**Response to Submissions
Mosman High School Upgrade
SSD 10465**

This document is provided by Woods Bagot, the architects for the project, as a response to the relevant submissions provided by DPIE, for the Mosman High School Upgrade State Significant Development Application.

3 Winter Solstice - 11am Proposed

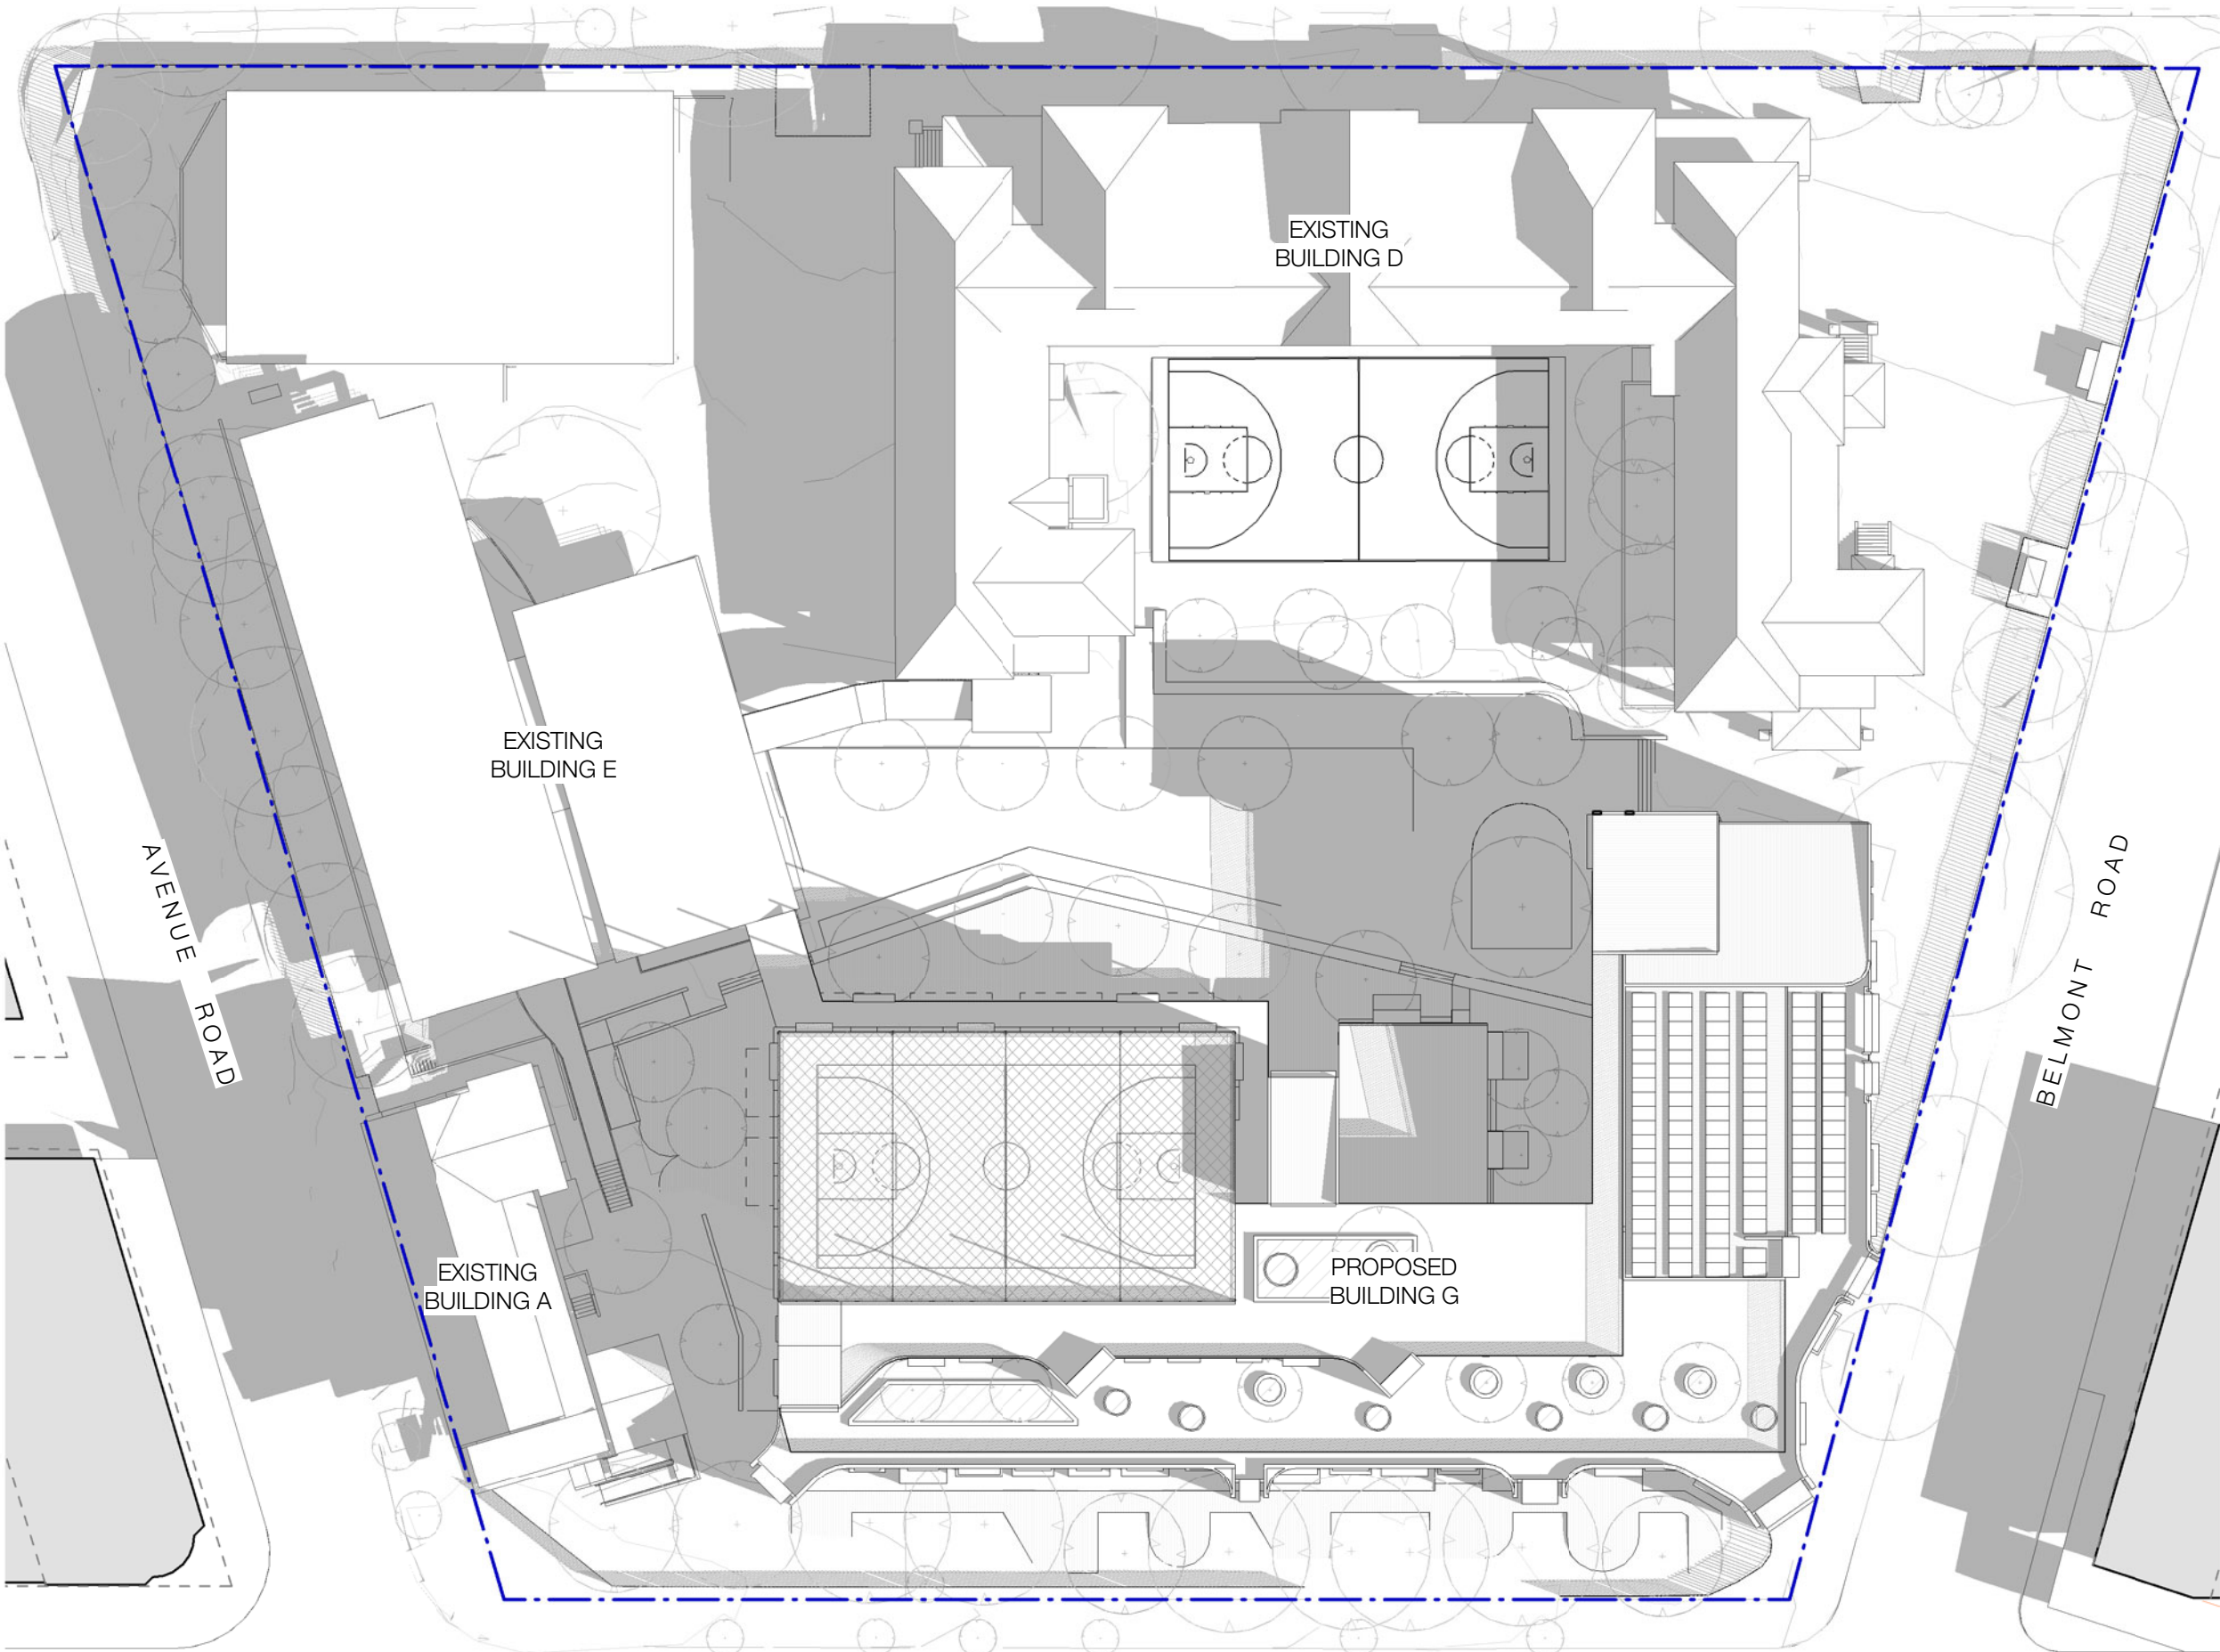
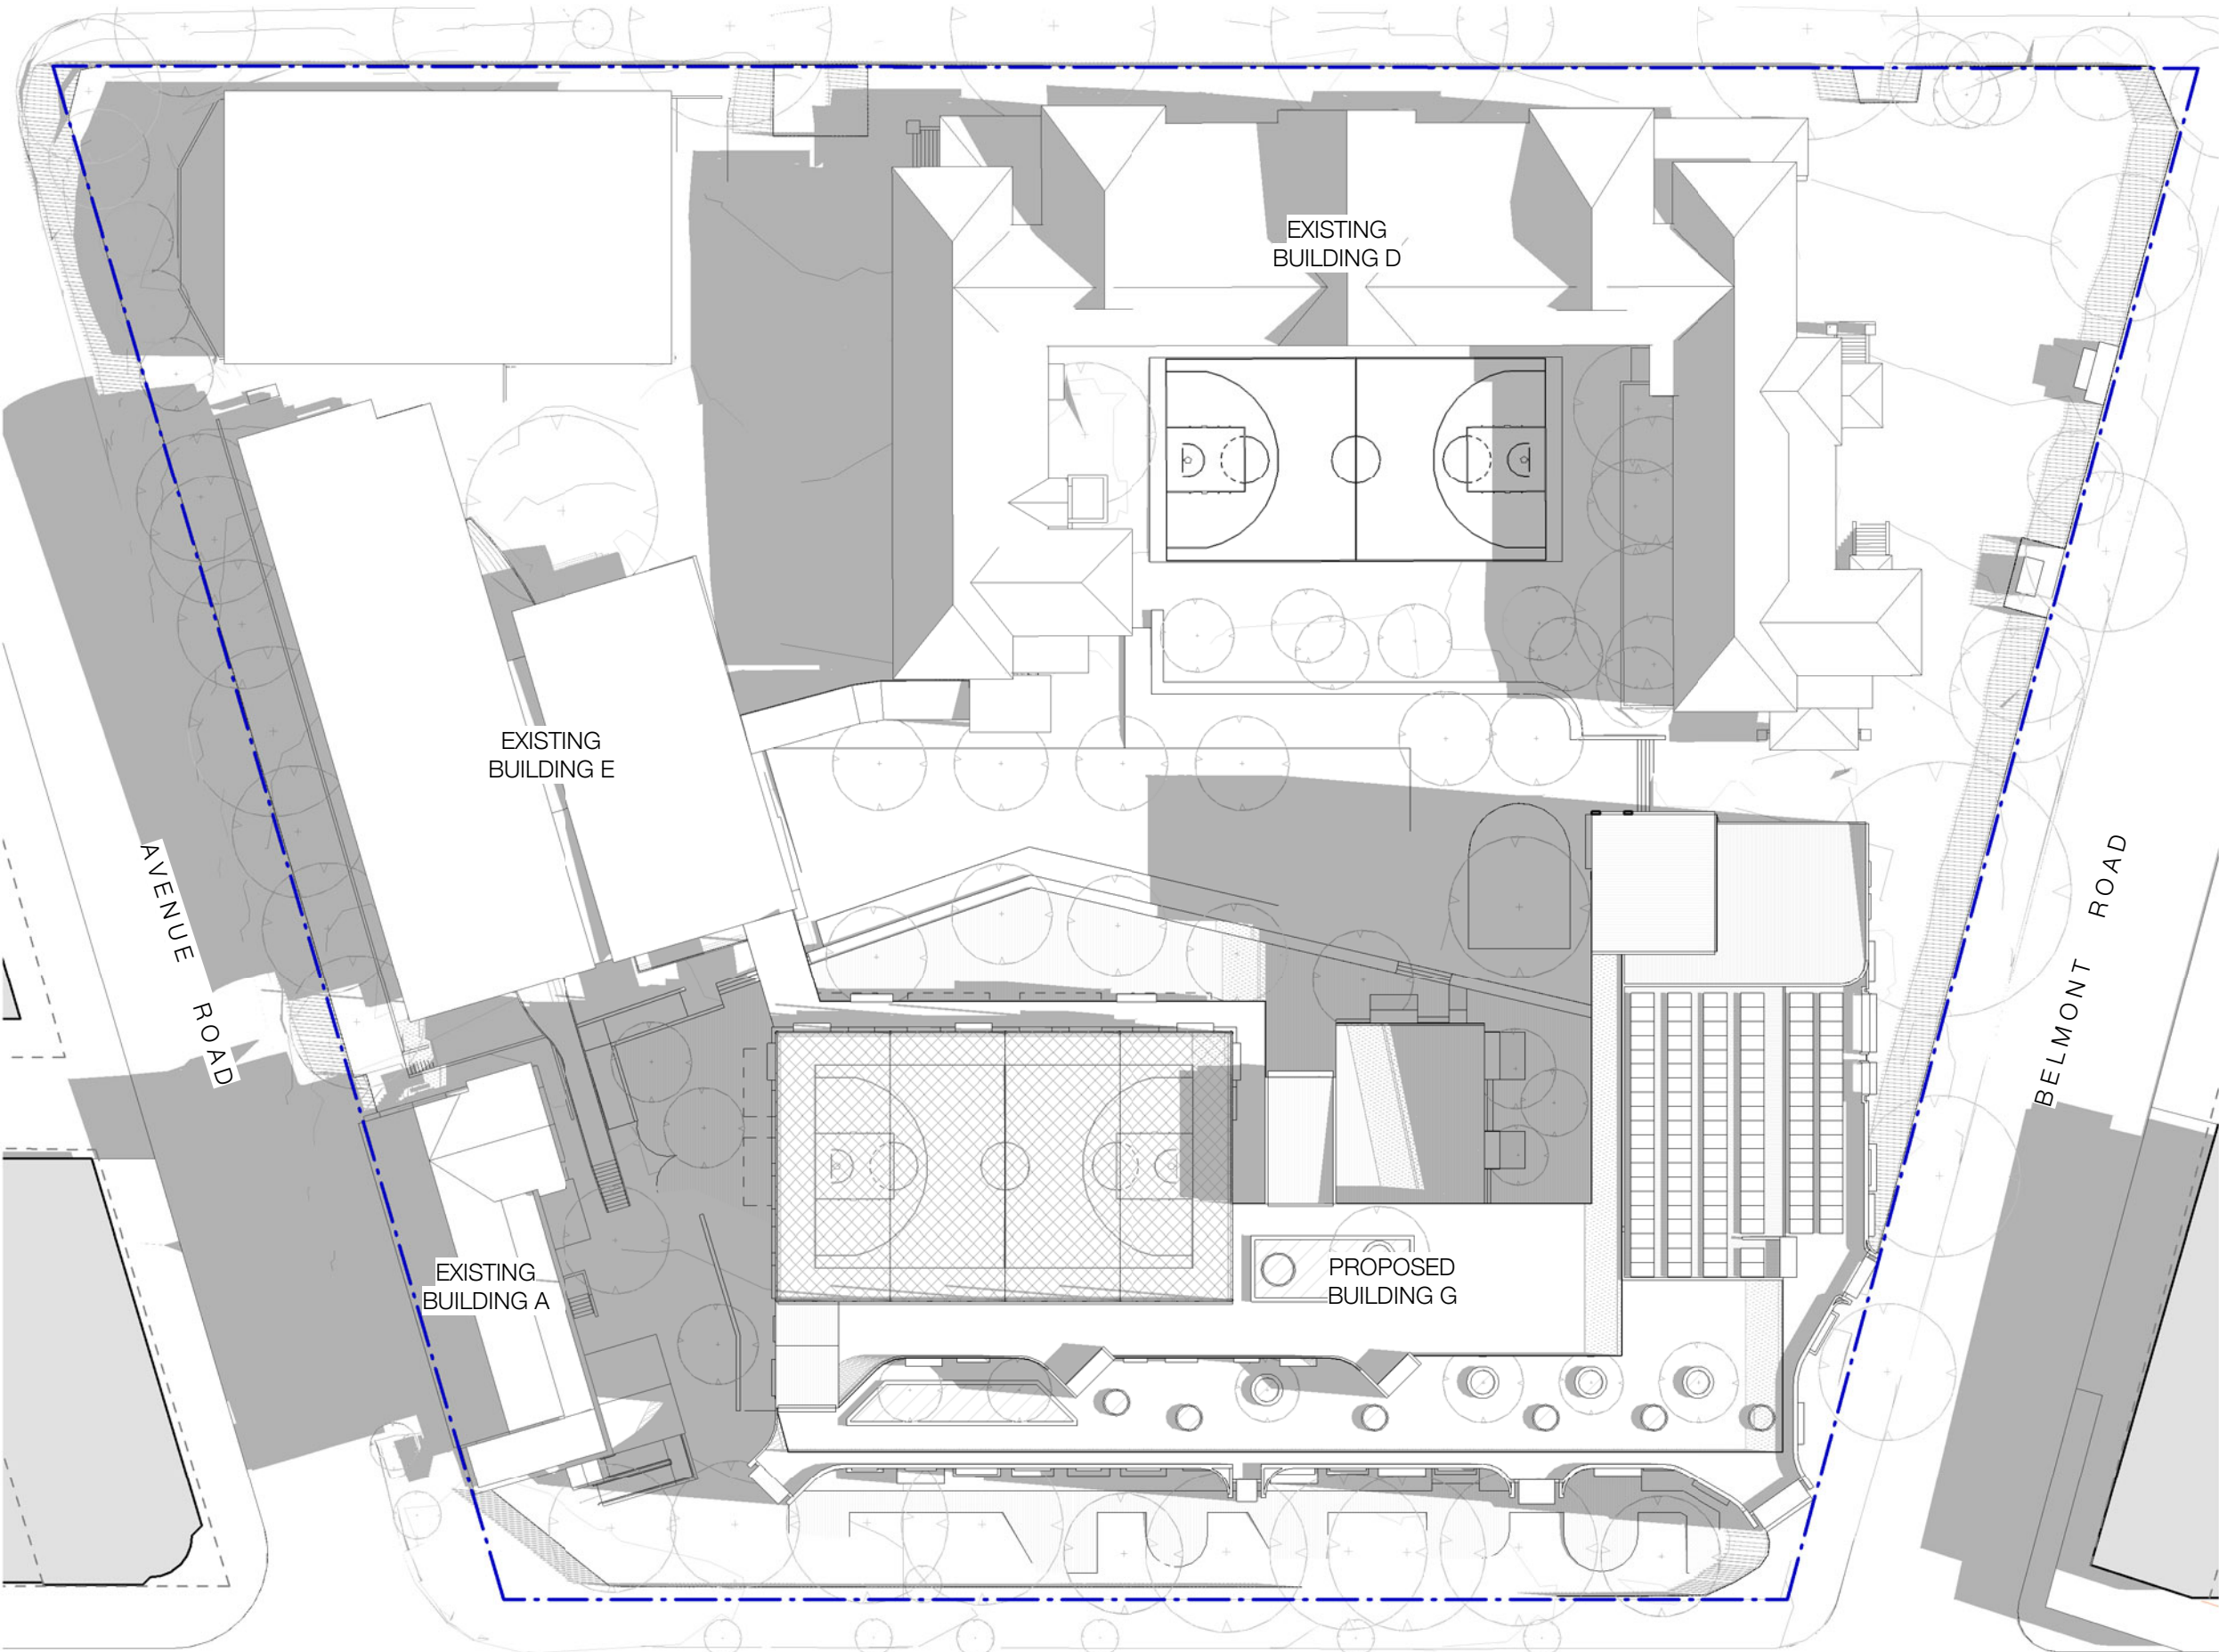
We note that plans submitted for public comment are only PRELIMINARY. This is unacceptable as they are technically incomplete and do not reflect the actual site complete shadow diagrams. Evidenced by the missing presentation of FULL SHADOW DIAGRAMS on impacted (Morning) Belmont Road, Keston Avenue & Avenue Road e.g. South West corner 6:00am(Summer) to 7:30am(Winter). Let's be honest – Easterly morning sun shine is critical to our neighbours amenity. (Afternoon) – Military Road retail shopping strip (Winter) 3:00 - 5:00pm. Let's keep the retail street sunny and a great place to shop.

Shadow diagrams are enlarged to capture the extend of Belmont Road, Avenue Road and Gladstone Avenue. There are no further shadowing impacts to Keston Avenue from Proposed building G from 9am to 3pm, winter and summer solstice.
